### Application for Planning Permission

**Development:** Subdivision of existing curtilage and erection of 3 No 3-bedroom dwellings, retention of existing access and provision of landscaping (resubmission following FG/49/24/PL). This application affects a Public Right of Way and is in CIL Zone 4 and is CIL

**Location:** Kivesborough Littlehampton Road Ferring BN12 6PN

Site Plan

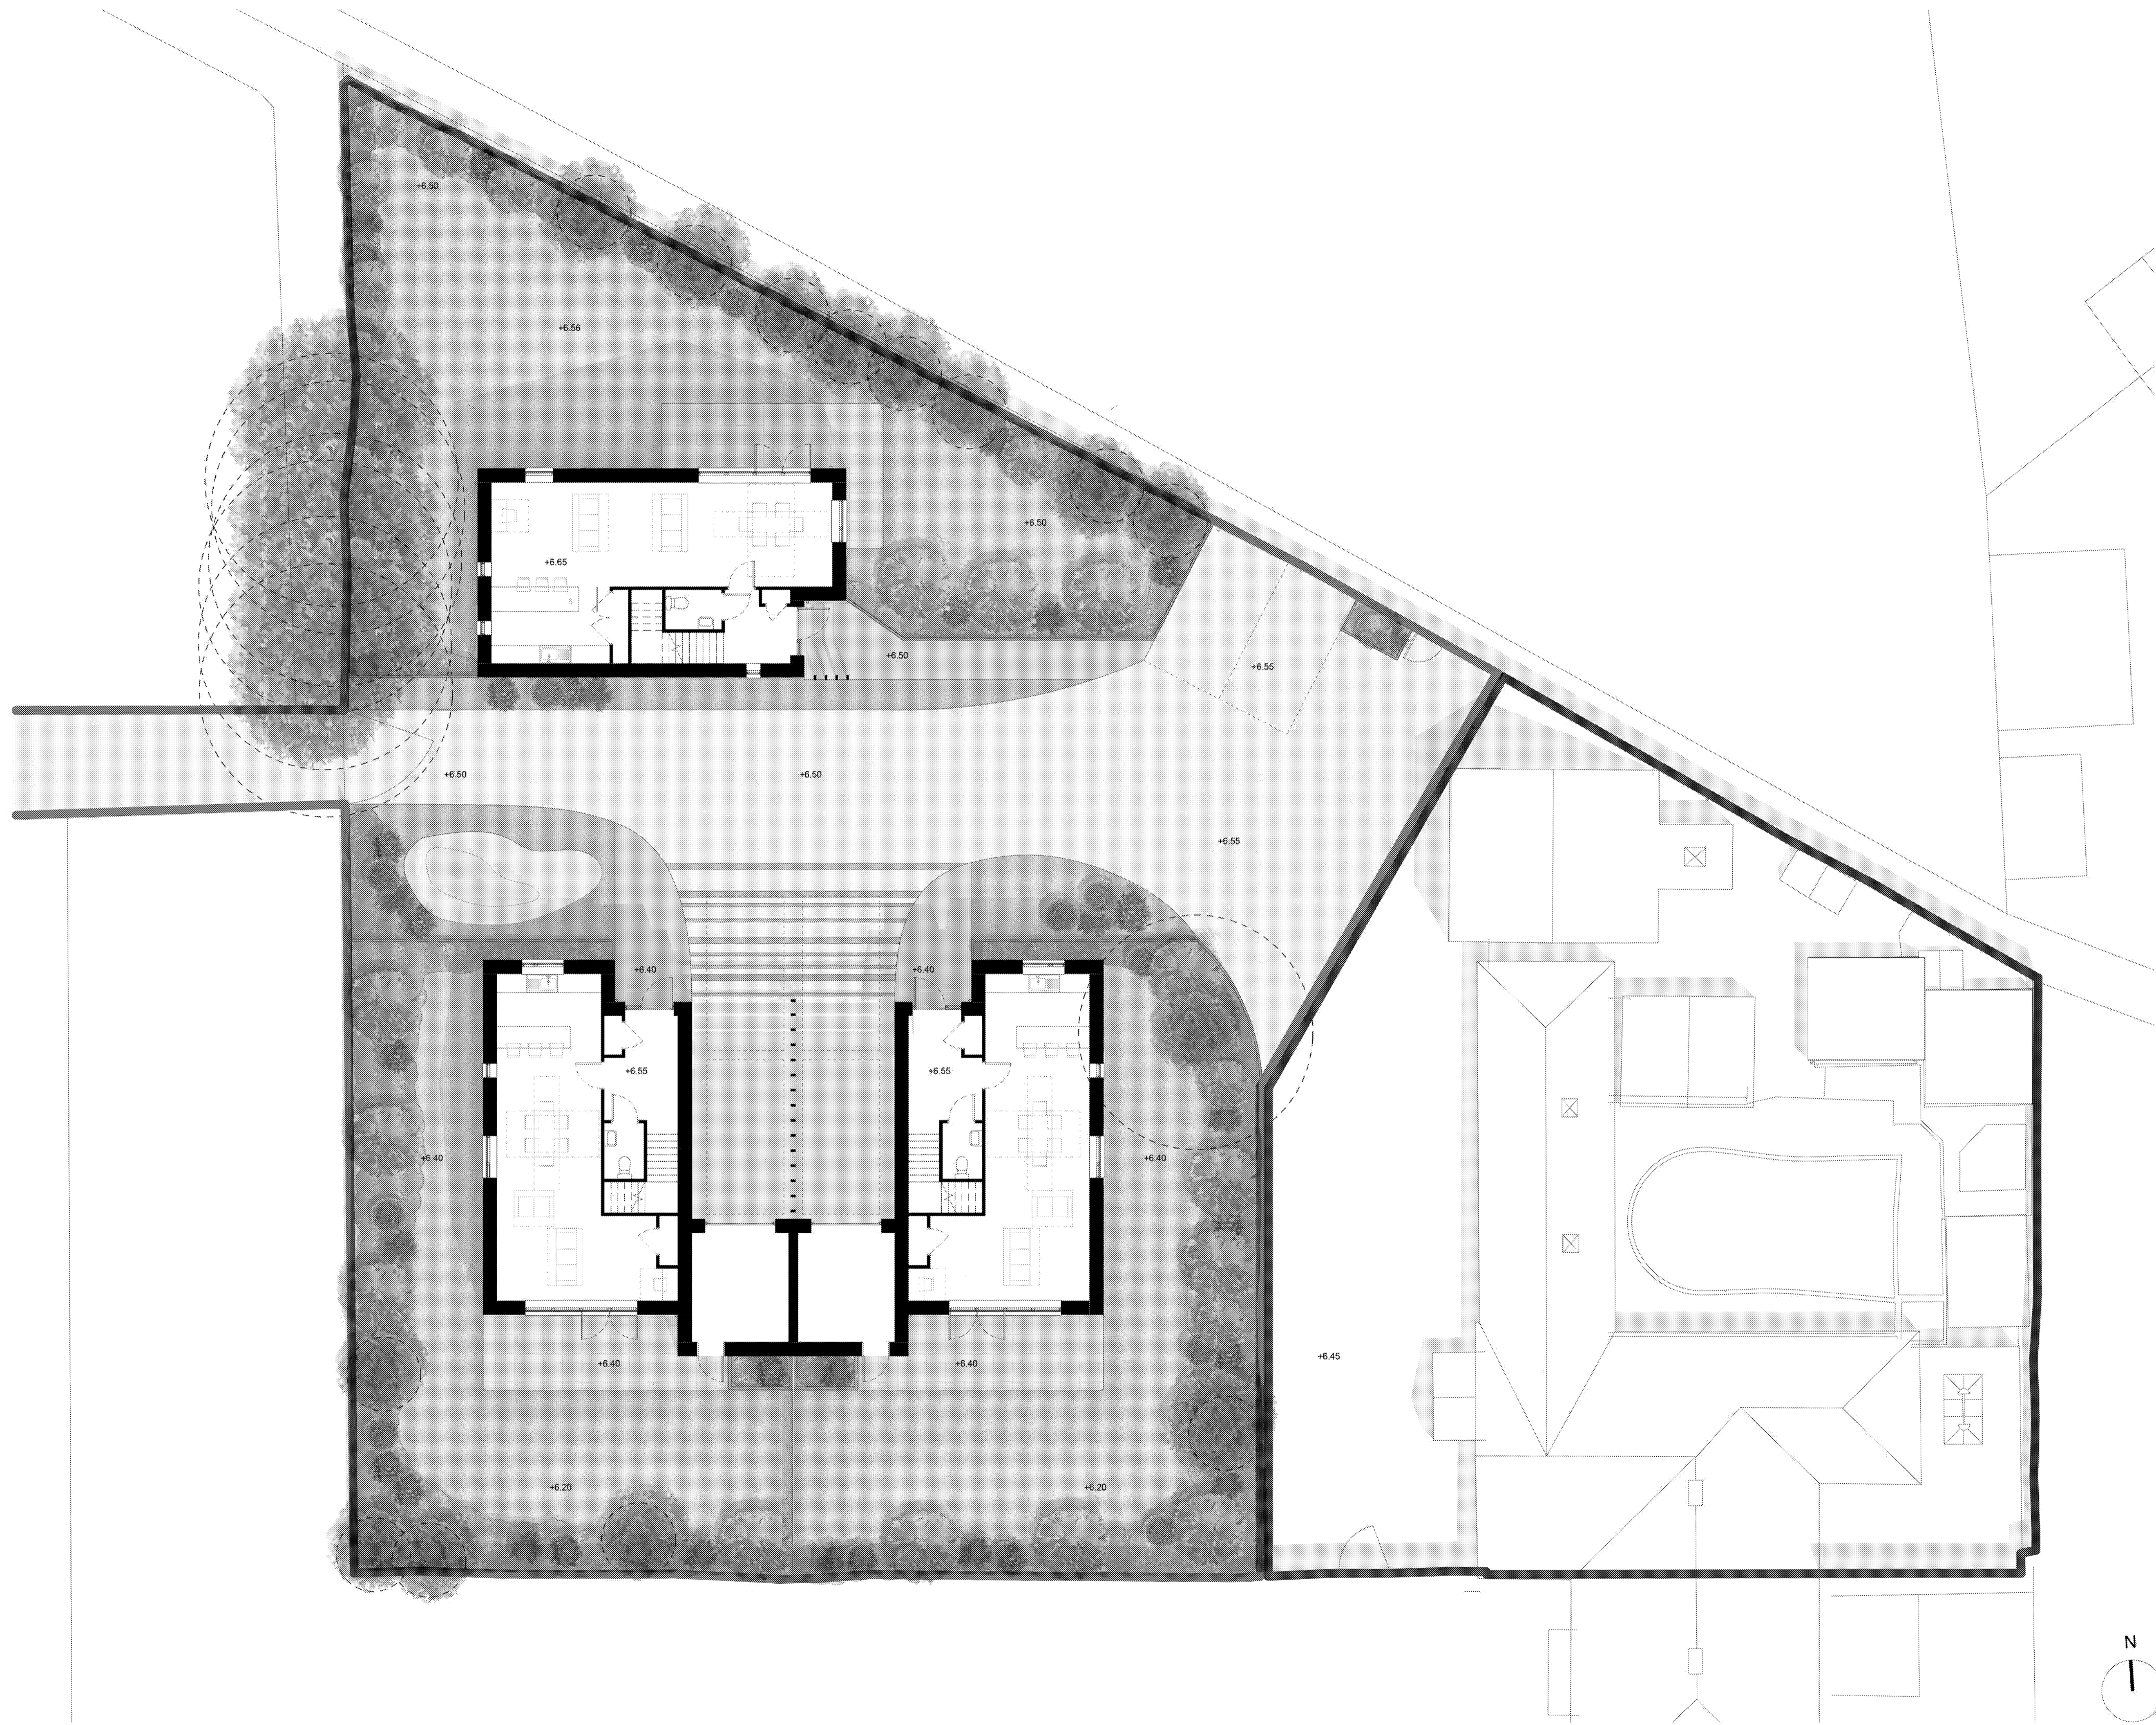
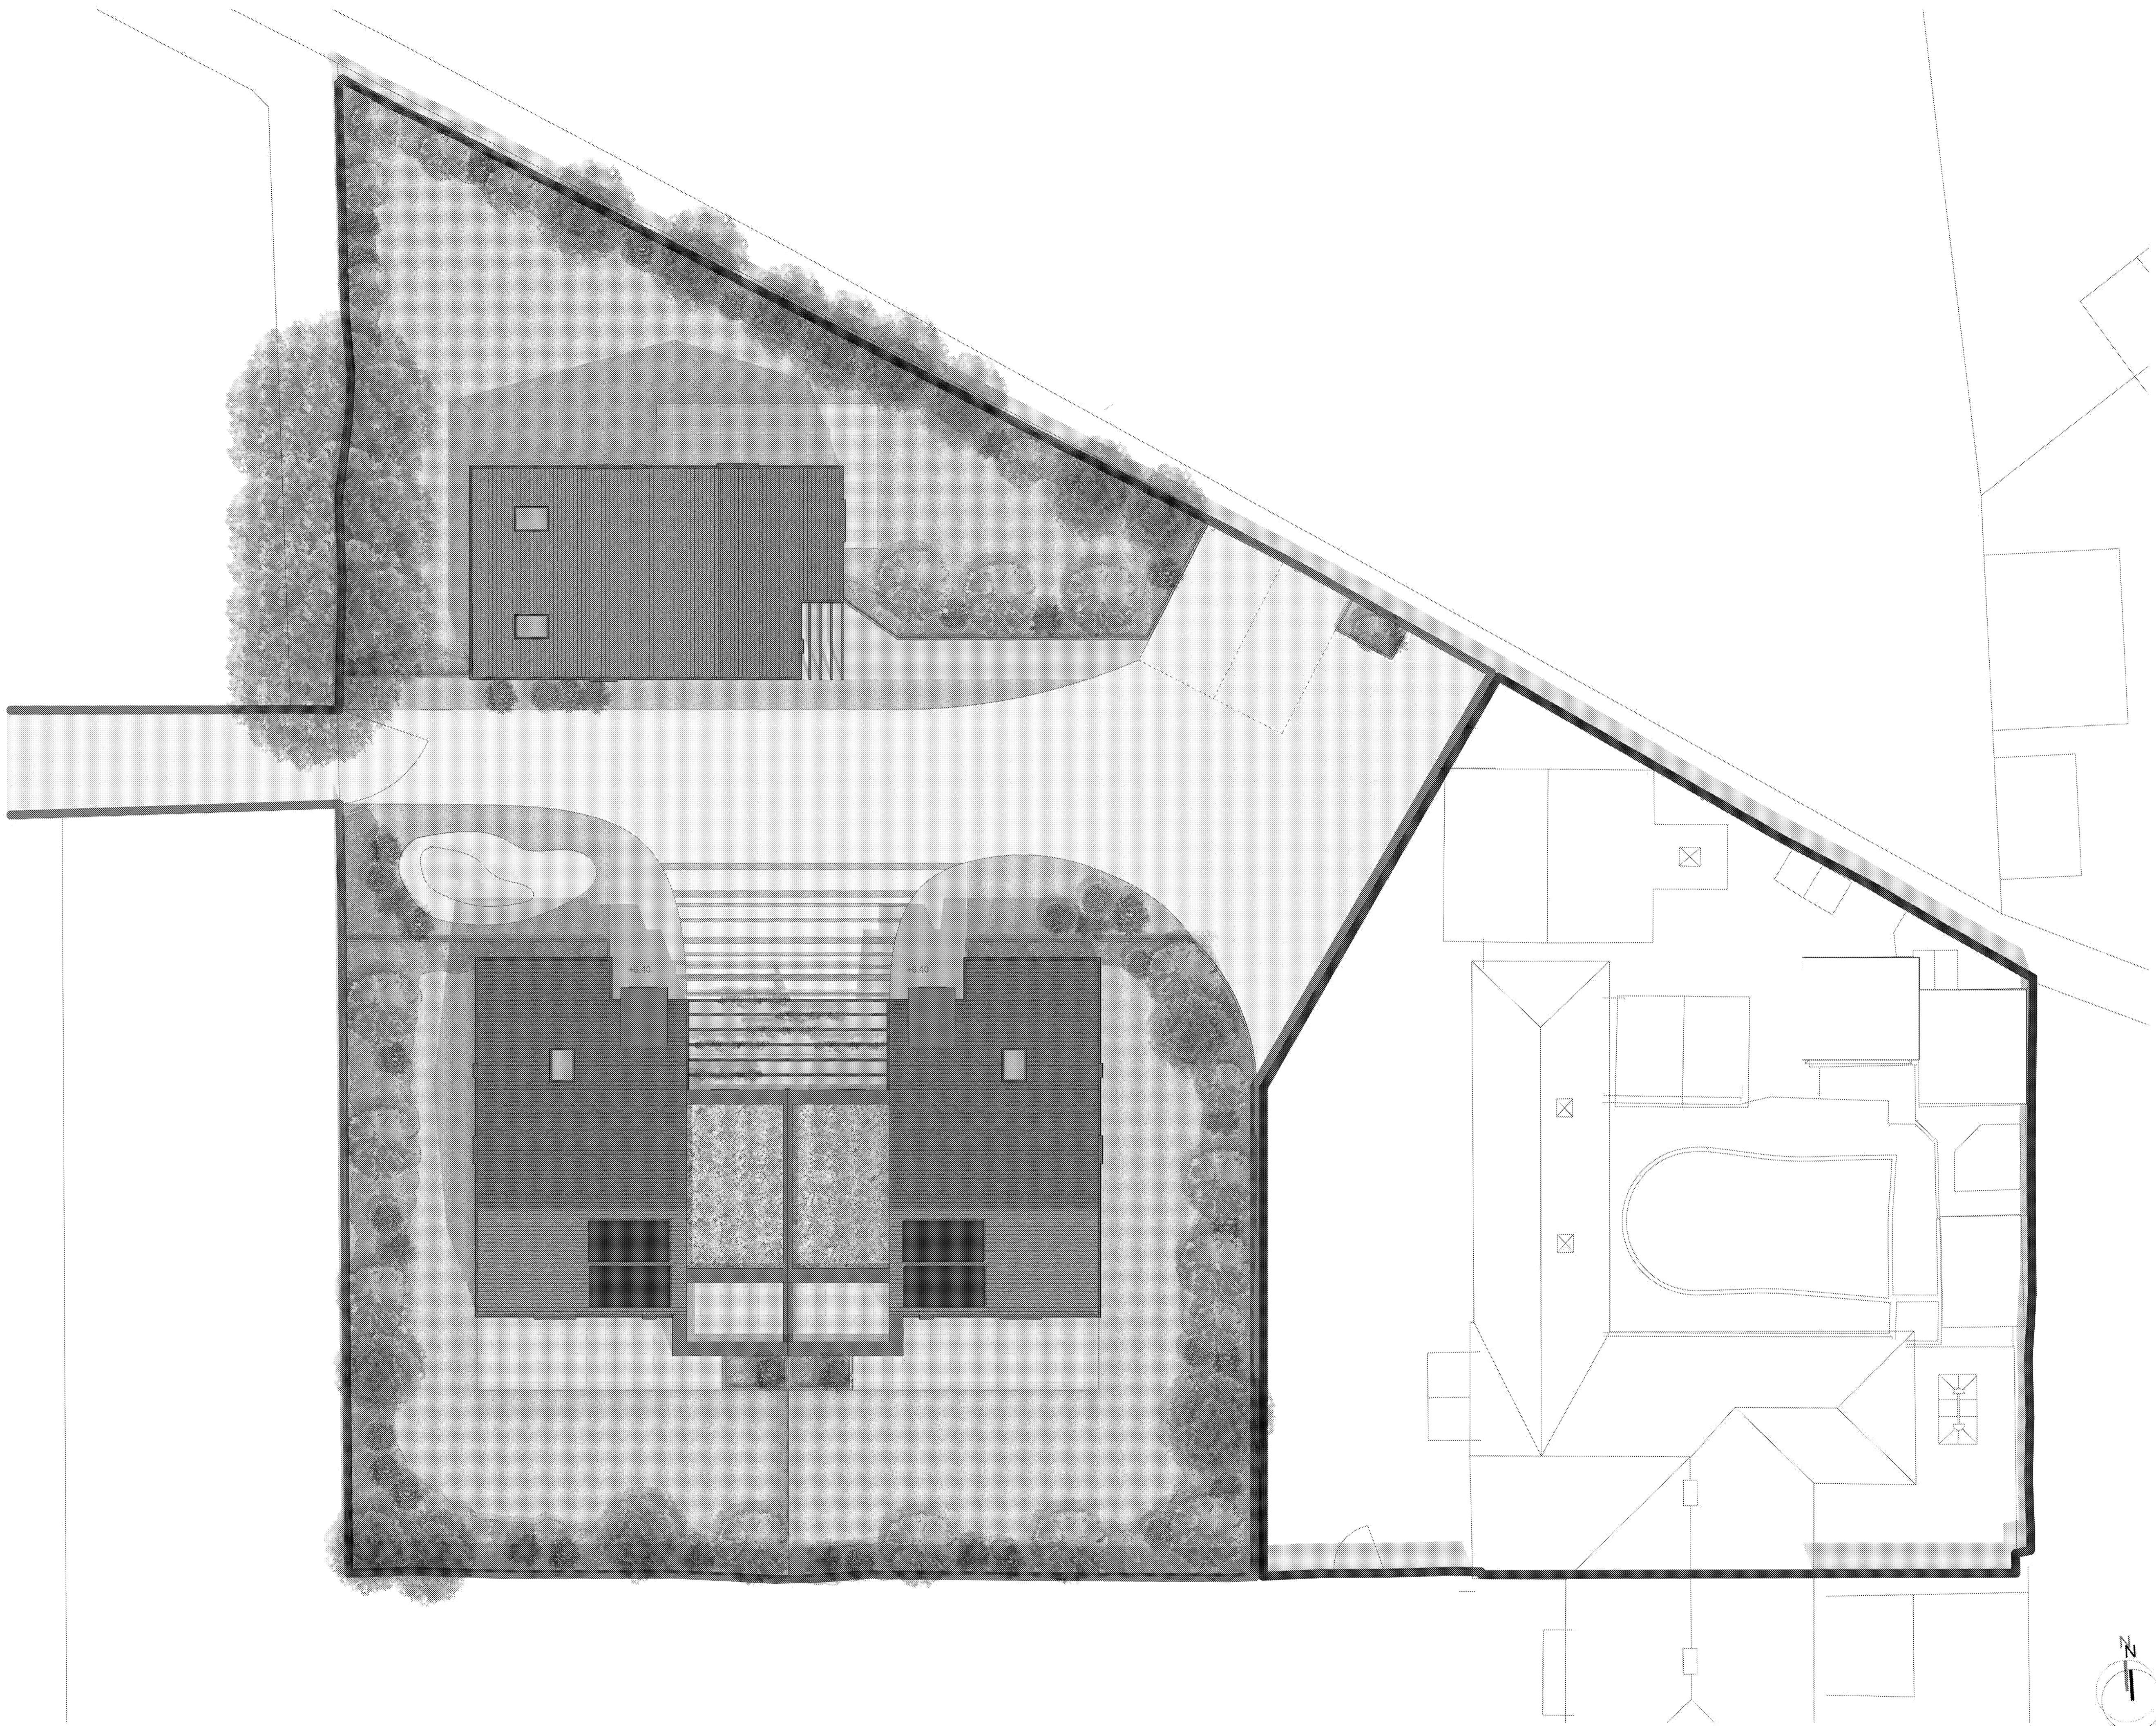
On the proposed site plan, please provide dimensions from the proposals to the site boundaries.
